Dear Sirs, Planning Application
R/267/17/PL
Ruskington Hall Nursing Home

FRONT ELEVATION - WEST with roof lowered
1m. Flat roof section 2400 wide approx

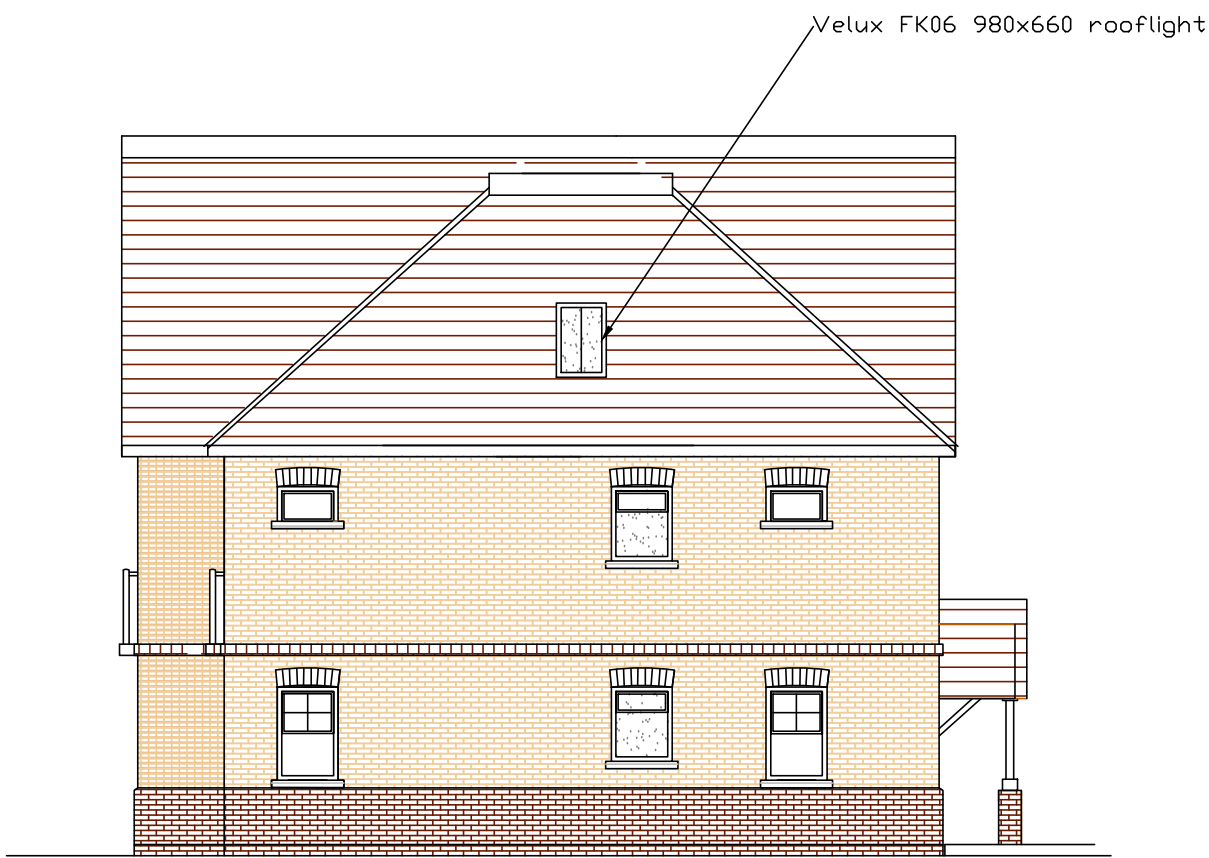
This roof is not a conventional up and over roof because it also has large side "Wings". The eastern "wing", which we will look at, is for the staircase to enable tenants to reach their flats on the 1st Floor, but it then continues upwards to access a door into the large storage area in the roof space.

Whereas we thought we would be seeing 2 storey flats with sloping up and over roof - we shall, in actual fact, be looking at a vertical wall 3 storeys high. (2 storey flats plus eastern "wing" 1 storey above the flats. This all a mere 2/3 metres from our back garden fence.

Our objection is the size of the roof with its "Wings".

We sincerely hope you will take our concerns on board when discussing this proposed newbuild at Rustington Hall - and hope the huge roof design can be changed to a conventional up and over roof the same height as Rustington Hall.
